2205-074 – InTake2

# Leung Residence

## Intake Screening Response

3 HARDSCAPE CALCULATOR - EXISTING
1/16" = 1'-0"

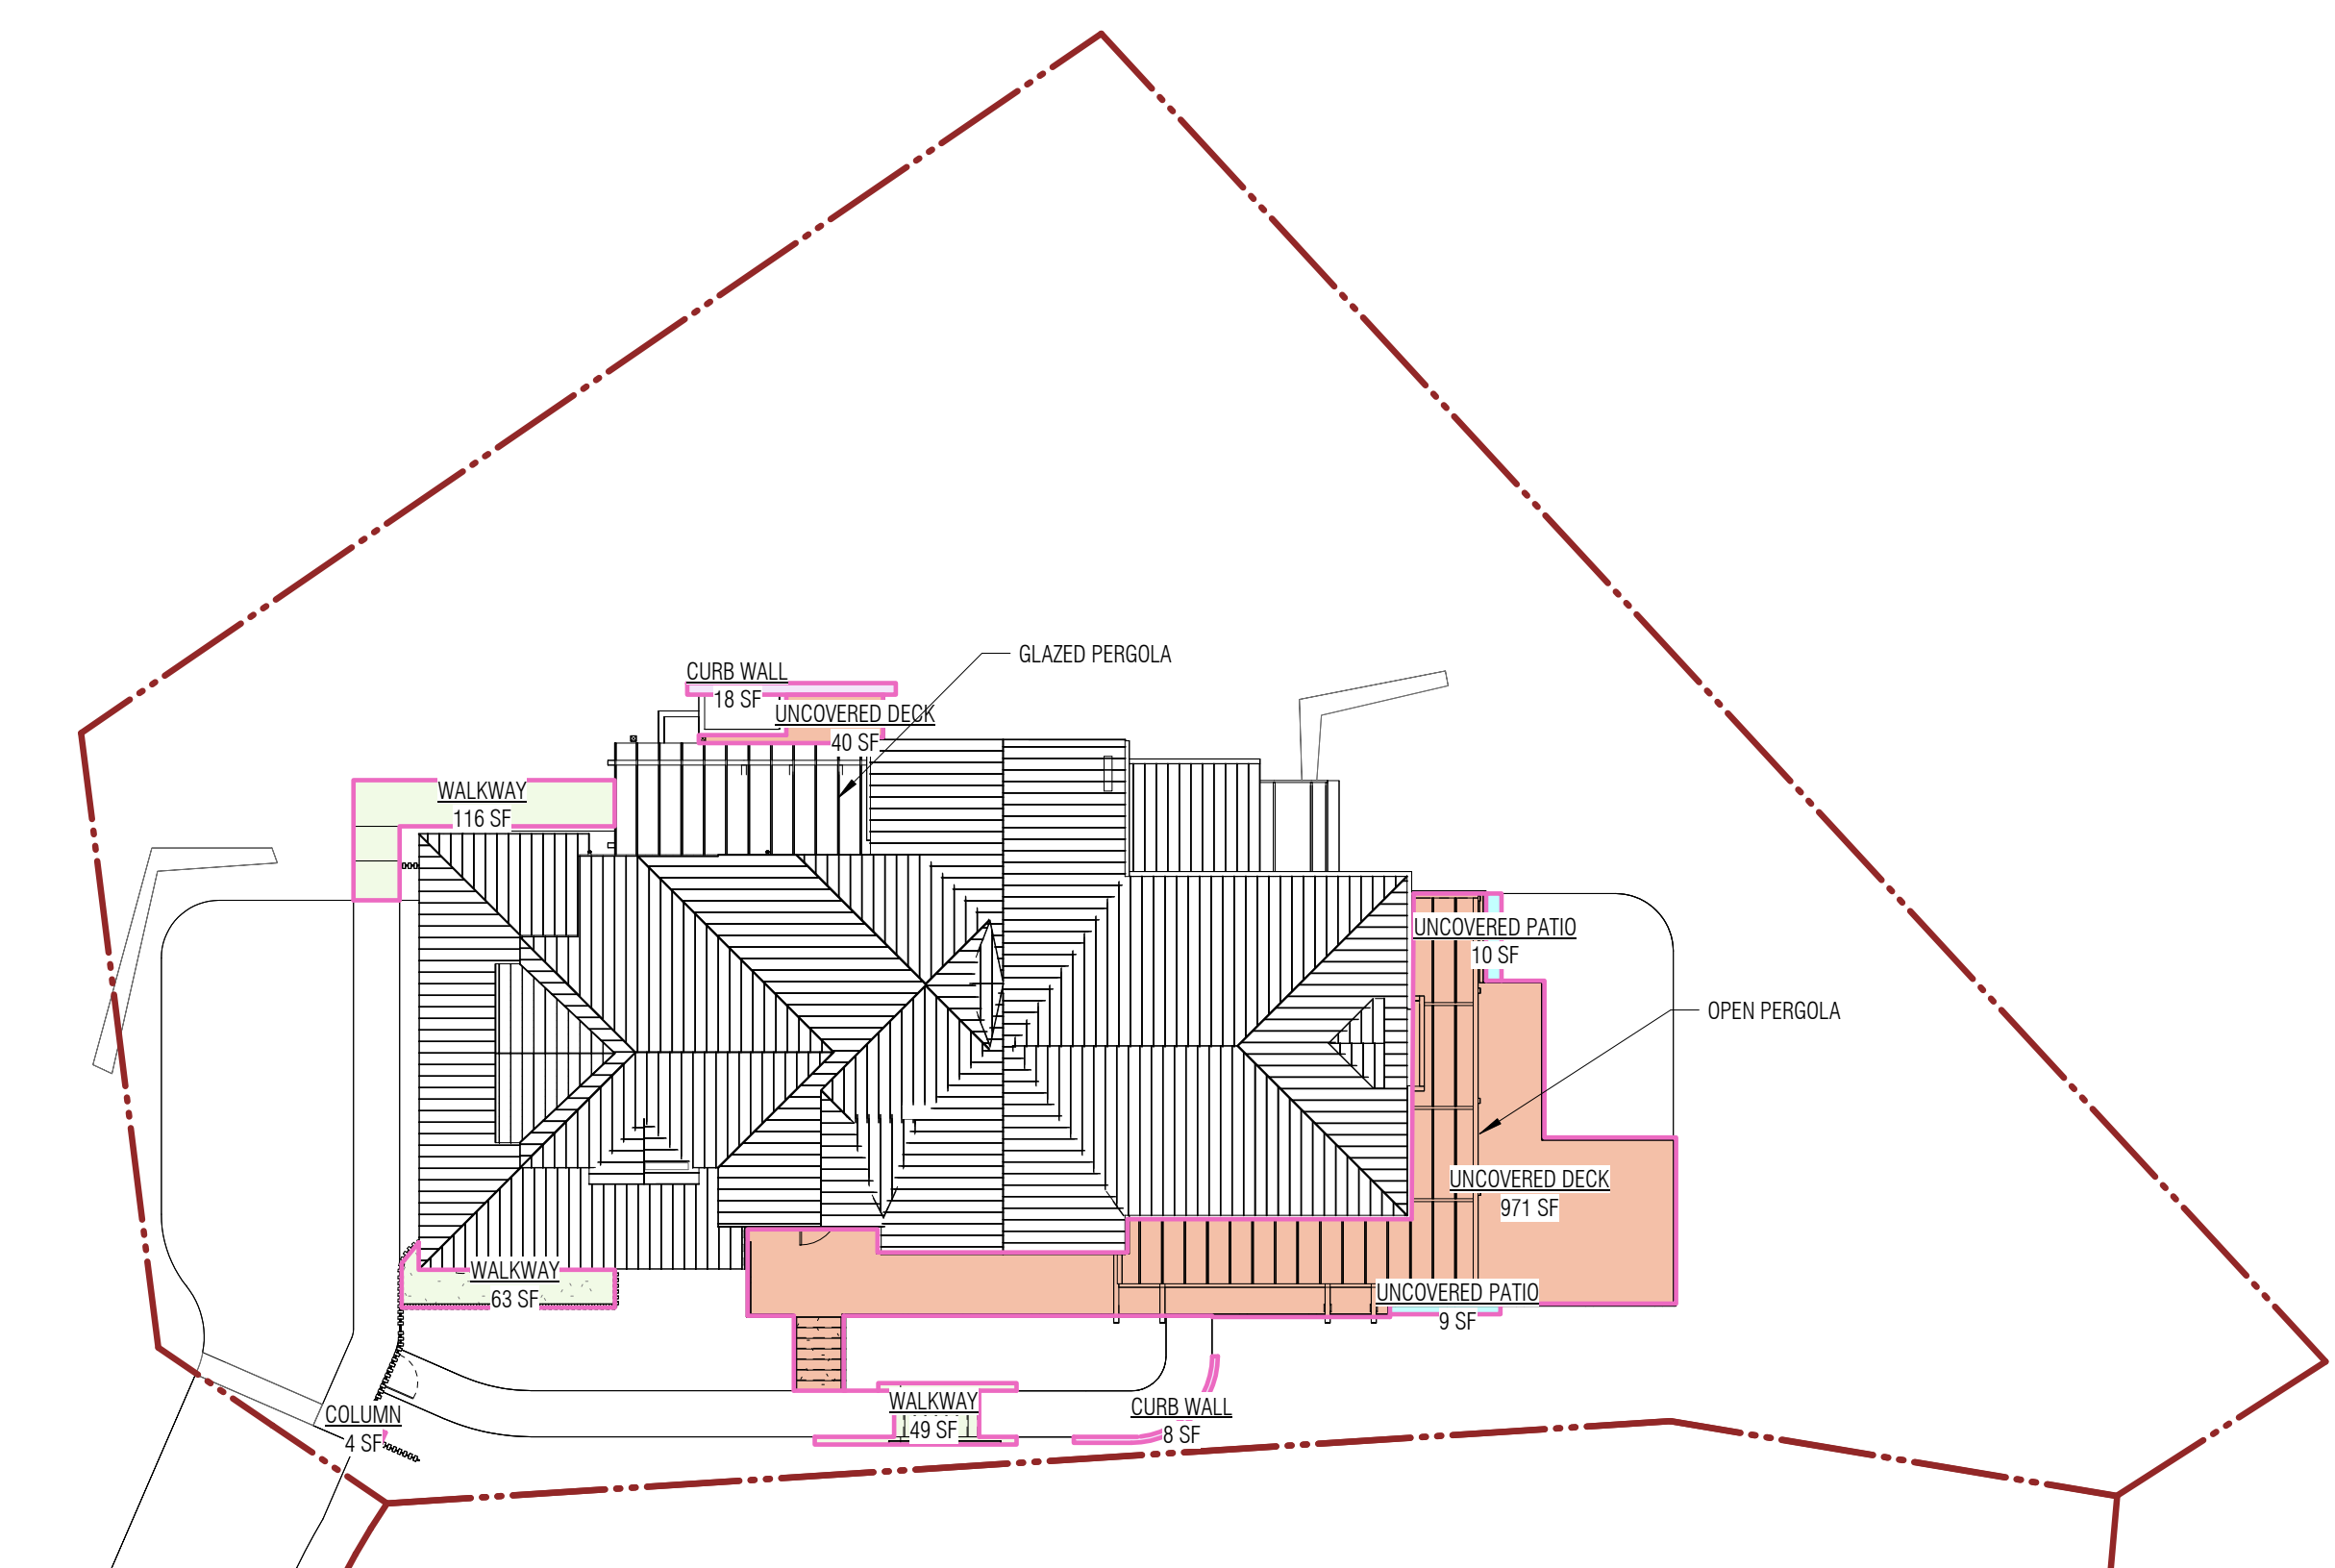
*The proposed glazed pergola is considered roof area and must be included in lot coverage calculations. This would likely cause the 30% lot coverage limit to be exceeded. If you are proposing to remove existing lot coverage to allow new lot coverage as allowed under MICC 19.01.050(F)(3)(b), please demonstrate how the requirements of MICC 19.01.050(F)(3)(b) are being met.*

*The proposed hardscape exceeds the 9% limit set forth by MICC 19.02.020(F)(3)(b)(i). Please revise the proposed hardscape to comply this this limit.*

*It also appears that the synthetic turf to the northeast of the house was not included in the hardscape calculations. Synthetic turf is included in the definition of hardscape and must be included in hardscape calculations.*

Response: Proposed south glazed pergola has been updated to be an open trellis design pervious to the decking below. Hardscape Calculations and Lot Coverage Calculations on Sheet G1.03 have been updated to reflect this. All plans have been revised to reflect the open pergola design and notations. See sheet A1.01 for building setbacks and location of pergola, no portion of the proposed pergolas open or glazed extend into the building setbacks.

Response: Please see sheet G1.03 for updated Hardscape Calculations and sheet L1.21 for updated Landscape Plan. The site plan has been updated so that the hardscape now falls under the 9% max limit per MICC 19.02.020(F)(3)(b)(i). The synthetic turf material has been revised to natural turf and soil management plan (sheet C2.1) and Drainage Report (sheet 34 and 35) have been updated to reflect that.
